## **CSELR – ATC Randwick**

### **Landscape EIS Review**

01
Zones

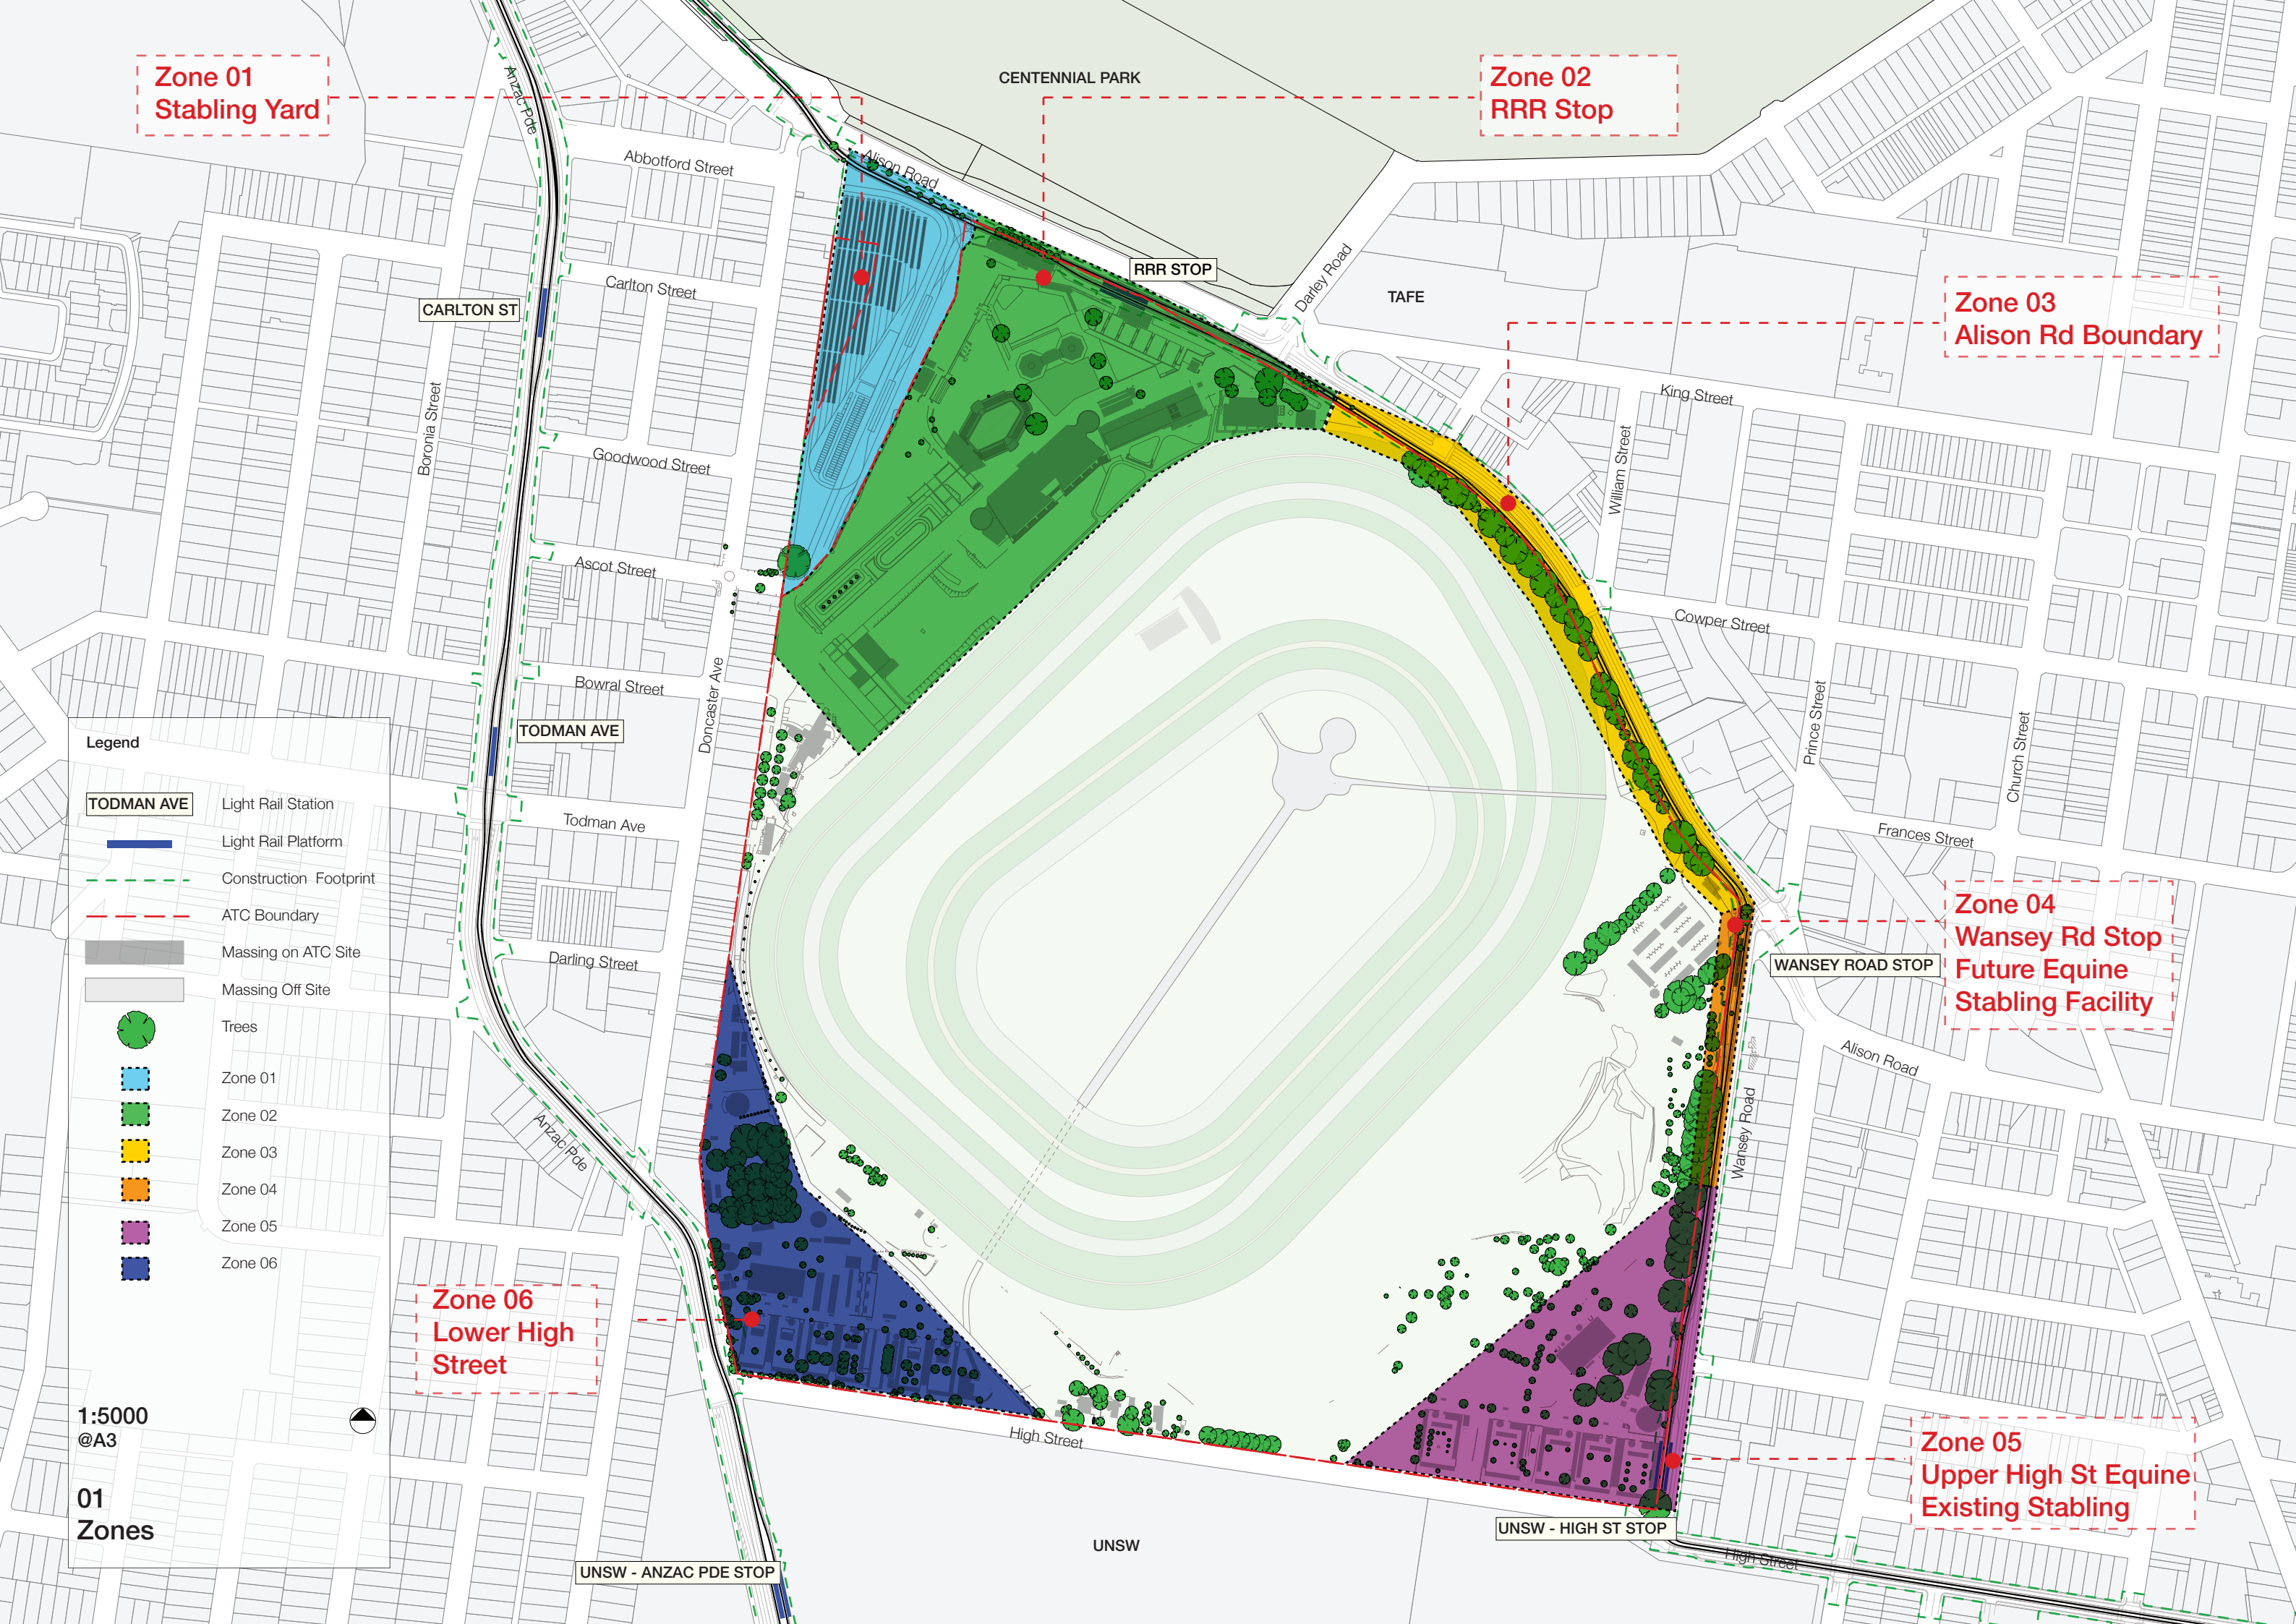
## Zone 01 - Stabling Yard

- b) There will be significant loss of plantings to the stabling yard zone (refer Fig 1, site photos of existing Ficus Macrophylla).
- c) There will be a significant impact of the Alison Road frontage (approximately 135m in length) which is a key frontage on the approach to the main race course entrance.

- f) Trees proposed to be removed within this zone are classified in the Randwick Comprehensive Development Control Plan 2013 as of "exceptional significance". Refer map 4, tree group 12 of the RRRDCP 2013. Also, refer the Royal Randwick Racecourse Conservation Management Plan and the LEP 2012.

- h) "The Randwick stabling facility site would be configured so as to retain the large Moreton Bay Fig at the western end of the site". (Chapter 15 Vol A-P66). However there are numerous large figs within this area and none are shown to be retained in Figure 5.50 Randwick stabling facility - indicative layout (Chapter 5 Vol B-P70)

- e) Trees of significance, as outlined in the RRRDCP 2013 (as illustrated in Figure 1 ), shall be transplanted (to agreed locations) to reuse a valuable asset and create an immediate landscape presence, embracing the parkway theme of this portion of LRT line and retaining the heritage and habitat values, embracing sustainability principles.

- f) Any stabling facilities and associated elements such as sub stations must be harmoniously integrated into the future proposed landscape and located outside of primary viewing lines, preferably underground and definitely underground on Alison Road frontage.

Impact Plan 02
Wansey Rd Stop

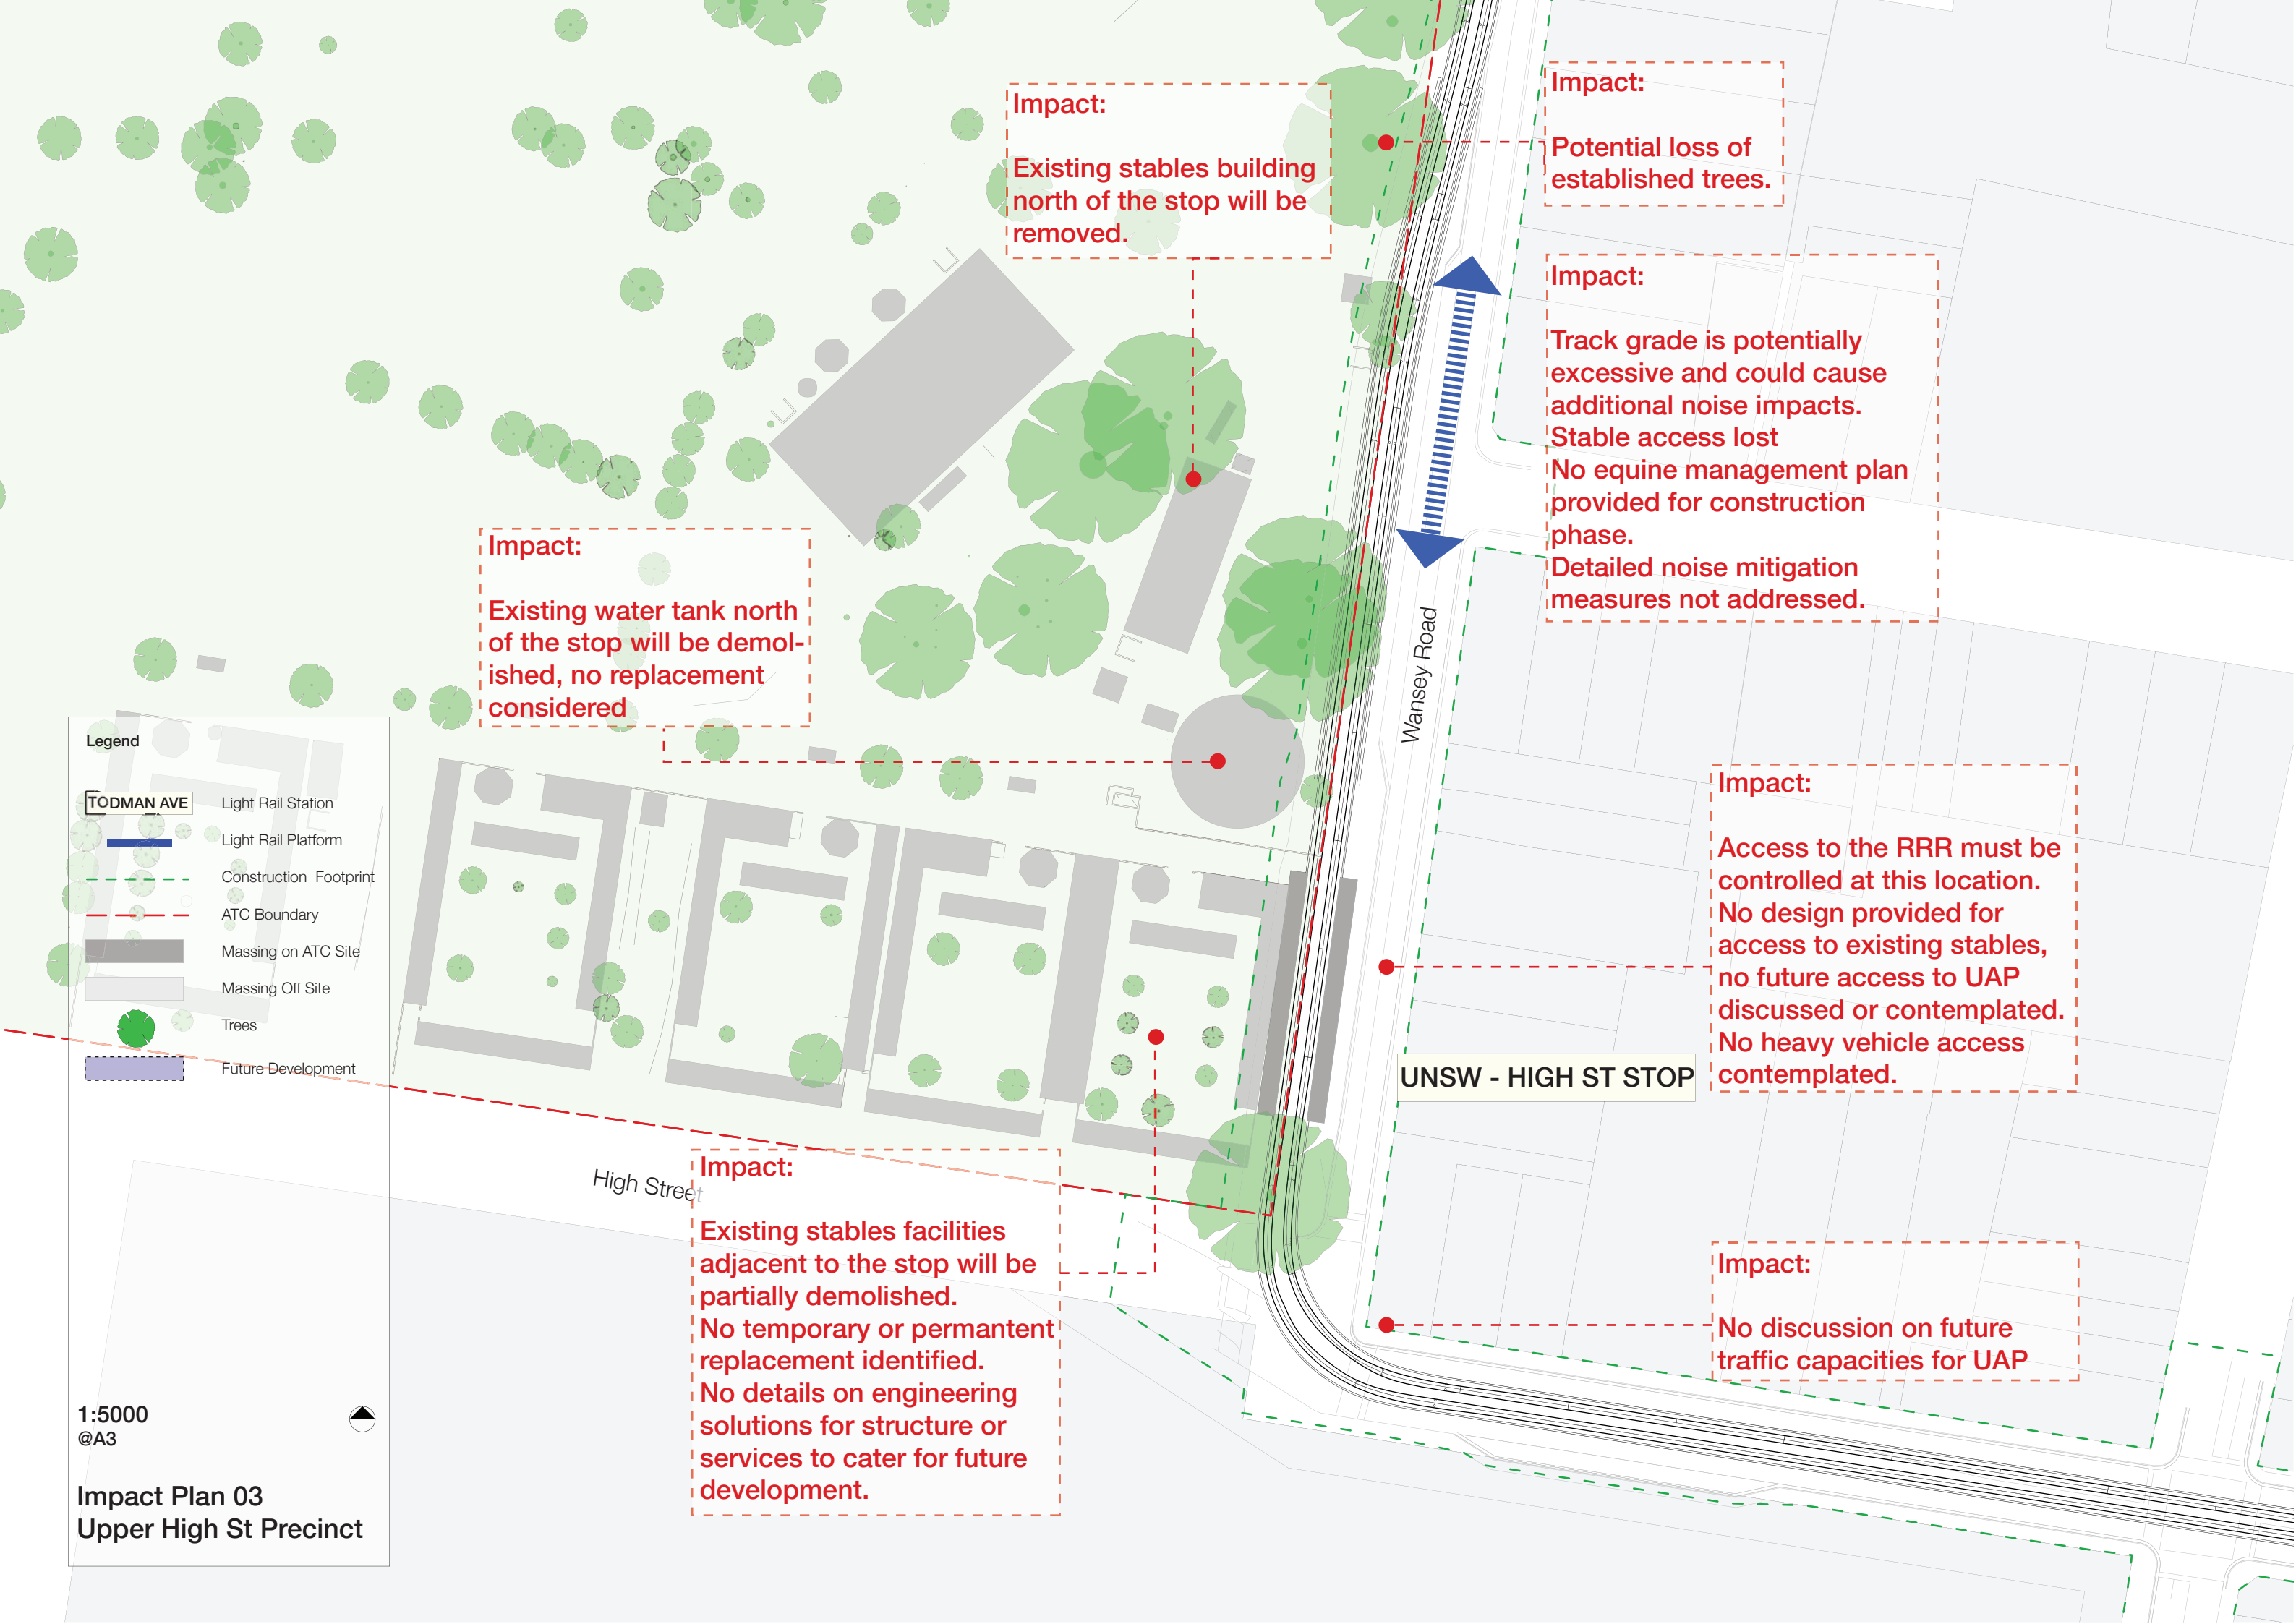
- a) The proposed Wansey Road stop will require "the trees along the western side [would need] to be removed prior to construction" (see Vol 1B Chap 5 p42). Refer Figure 3 of appendix 1.

- c) The removal of the significant trees along the western edge of Wansey Road will significantly impact the site. They currently provide a green backdrop to the Racecourse as viewed from the spectator precinct.

- g) The proposed Wansey Road stop cross section as illustrated in Figure 5.29 ” (see Vol 1B Chap 15 p42) shows an over-hanging cycle way, supported by a retaining wall, that “would have a maximum height of approximately 4.5 metres, with an average height of approximately 3.5 metres. The retaining wall would span approximately 125 metres”. A structure of such size would have a significant visual impact as the backdrop to the race course and would be seen by tens of thousands of guests from the main stand. (see Vol 1B Chap 5 p62). Significant consideration would be required for the structure and its screening to create an acceptable backdrop to this view.

- a) See proposed solution, Zone 01, points (a)-(e)
- b) Property boundary lines are absent from the drawings so it is impossible to ascertain the direct impact on RRR land. These will need to be defined so as to understand the immediate impact.
- c) The proposed design (both retaining walls and tree removal) needs significant development in the context of the above comments and the proposed materials palette.
- d) TFNSW should consider the planting zone within the new retaining walls to relocate existing Figs.
